Application No: EP/14/21/HH
Site Address: 38 The Roystons East Preston BN16 2TS
Description of works: Single storey side and rear extensions and conversion of roofspace to habitable use

Thank you for your internet representation made on 11th March 2021 which has been recorded as an objection with the comments as follows:

I am commenting on this application on behalf of the East Preston and Kingston Preservation Society.

Drawing
Proposed roof plan

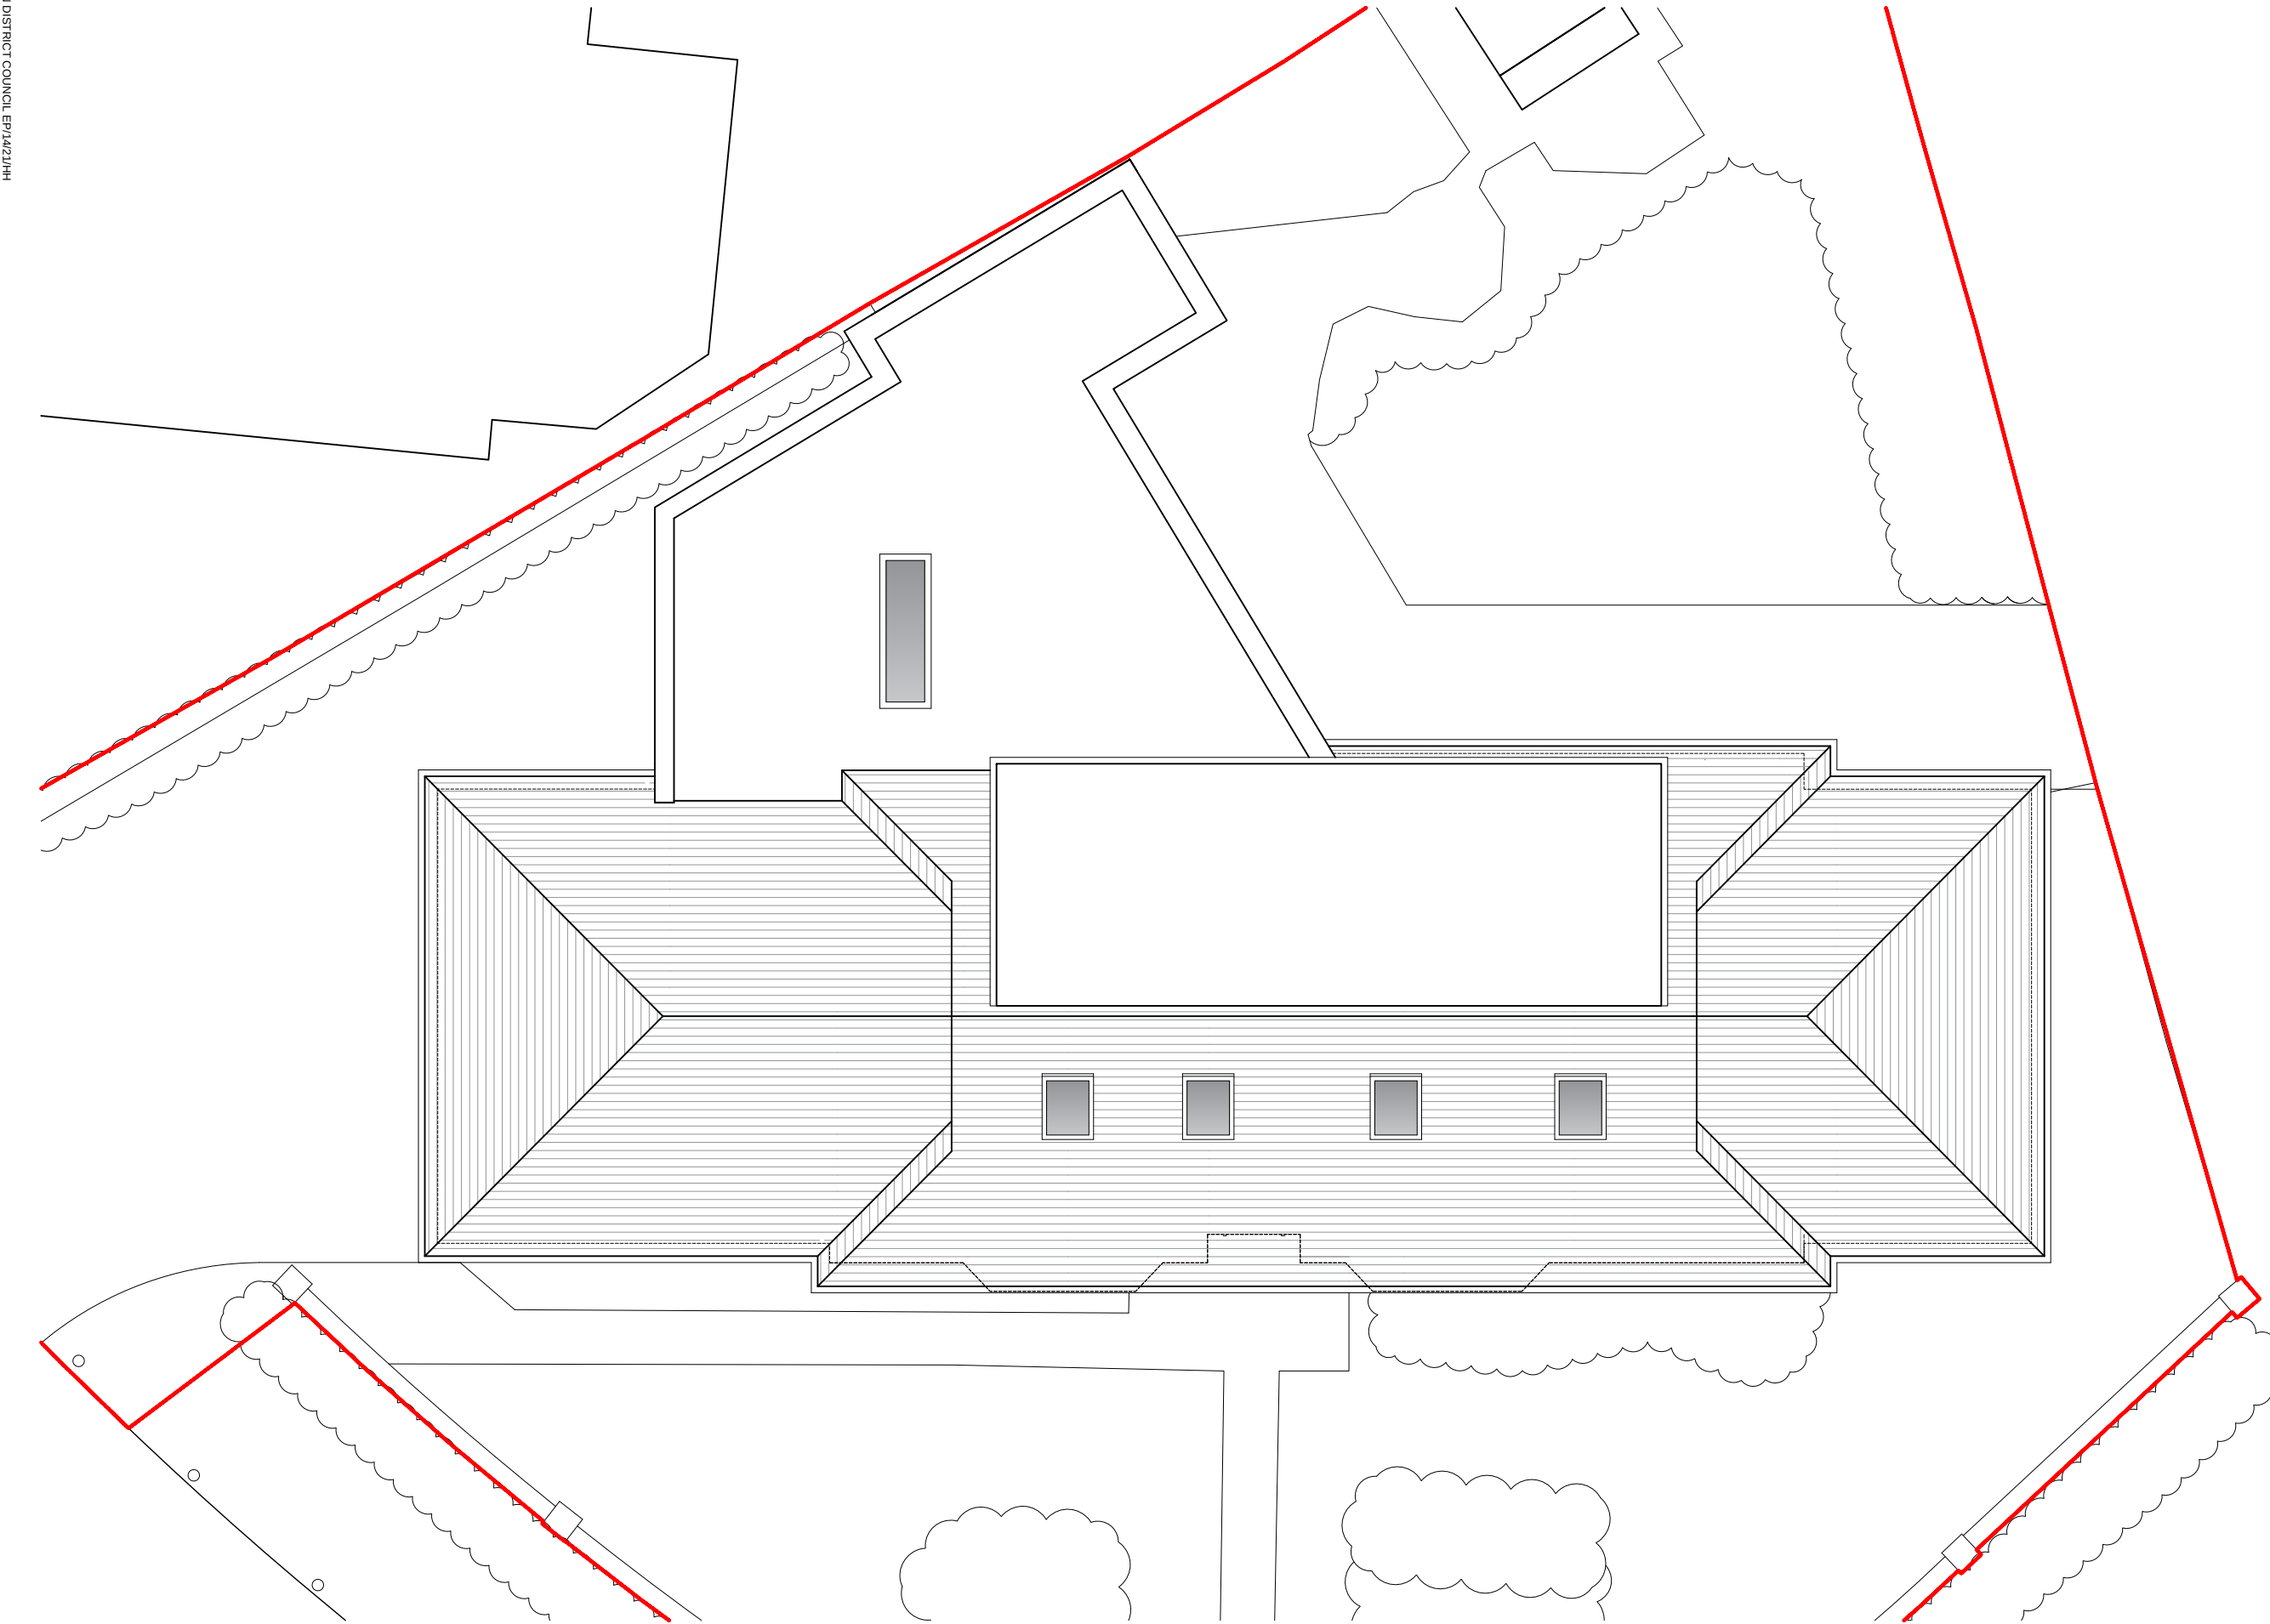
The proposed dormer window at the rear would conflict with Policy 1 of the Neighbourhood Plan by reason of

its size, and with Policy D DM1 of the Local Plan because of its overlooking impact on neighbours to the north.

Drawing
Proposed elevations

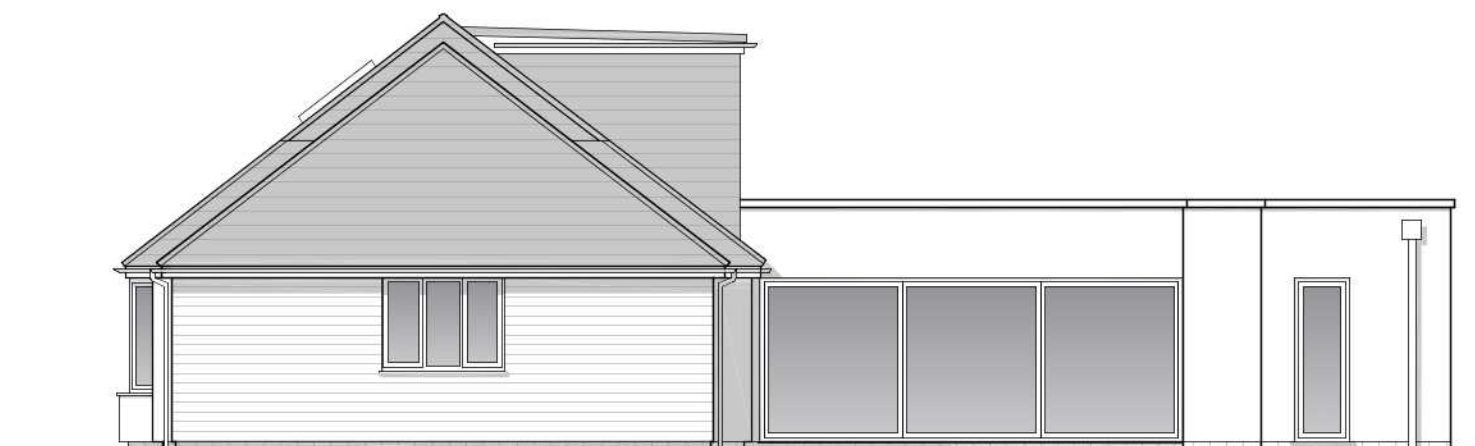
The proposed alterations would greatly increase its width, so that the building would extend nearly to the edges of the plot, and would add a large flat roofed dormer at the rear. The brick of the walls would be covered by white render and grey fibre cement boards, the leaded light windows in wood frames would be replaced by plain glass windows in grey aluminium frames and the clay tiles would be replaced by grey slate effect tiles. The predominant colour scheme would be changed from red and brown to grey and white.

The new materials would create a building that contravened both Policy D DM1 of the Arun Local Plan and Policy 1 of the East Preston Neighbourhood Plan, because the materials in other buildings in the area resemble those in the existing bungalow, and the altered bungalow would not therefore reflect the character of the surrounding area in terms of the materials used. These materials should harmonise in both colour and texture with those in adjoining buildings. The enlarged bungalow would also conflict with Policy 1 of the Neighbourhood Plan because it would be an example of alterations which would harm the character of a road.
